From: Chance, Jennifer
Sent: 22 January 2026 14:58
To: _planningadvice
Subject: H01-1245-25

For the sake of clarity, I have no objections to the housing development of 3 properties (plots 1-3). The objections are based solely on the proposed conversion of the Engine Shed (marked on plan as plots 4-5).

The Engine Shed (A.K.A the Goods Shed) is considered to be a non-designated heritage asset (NDHA) by virtue of it's attractive historic detailing and importance to the agricultural history of the locale, being recorded in the Lincolnshire HER under reference: MLI126584, which describes the building like so:

PROPOSED ELEVATIONS

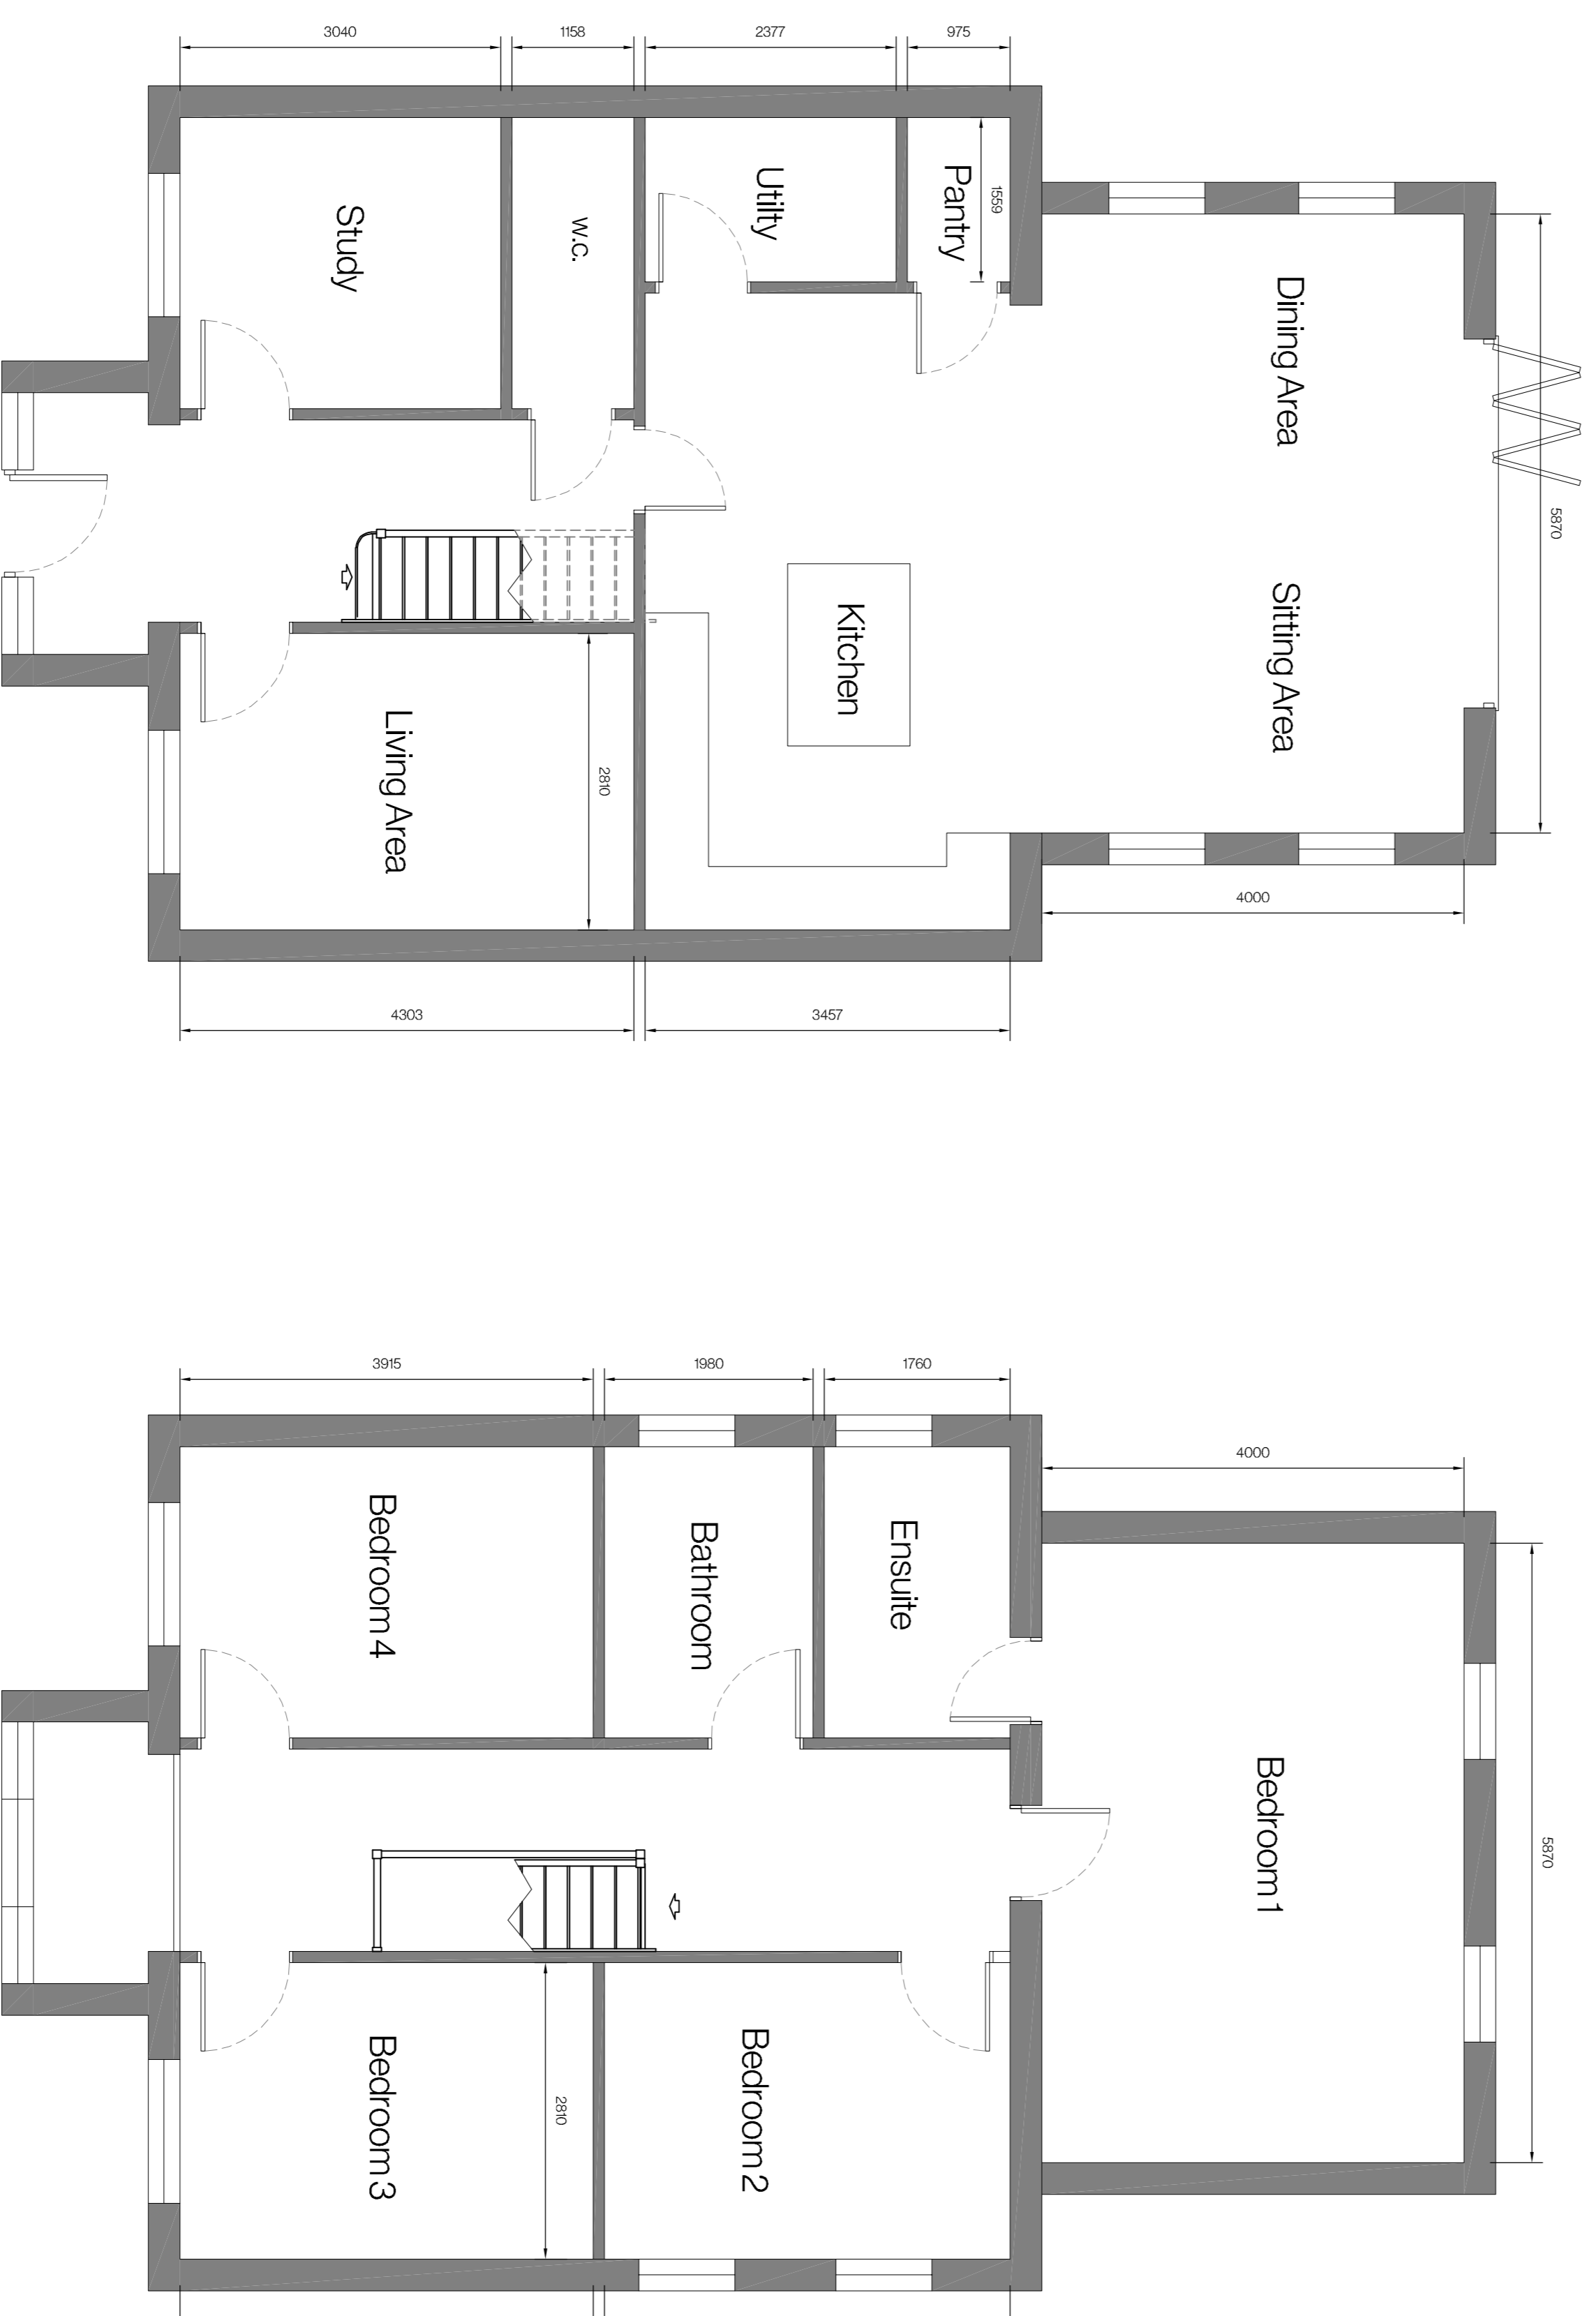
The proposed conversion of the Goods Shed seemingly makes no attempt at design sympathy with this attractive former rail building; seeking to infill and remove all readability of historic openings, reveals and recesses with marley boarding, and replacing character windows and doors with standard dimension PVC fenestration with absolutely no relation to the character of the existing. So great is the proposed harm to the NDHA, that I would suggest that the scale of harm should be recognised as at the higher end of ‘substantial’ as it seeks to effectively remove or substantially alter more or less every character feature of the structure, save for the chimney stack and pot, and would modernise the appearance of the asset to an extreme degree, resulting in an unattractive form of development. In accordance with this view, I would therefore recommend that without amendment, Para. 216 of the NPPF should be used as justification for a refusal.

Should the applicant be minded to seek amendment, I would suggest that the whole principle behind the proposal should be rethought totally. The agreed class Q conversion under application reference: H01-0098-24 showed that a sensitive and high quality conversion of this building is not outside of the bounds of design, and should be seen as a useful baseline standard in informing what form any future plans for the Goods Shed may take.
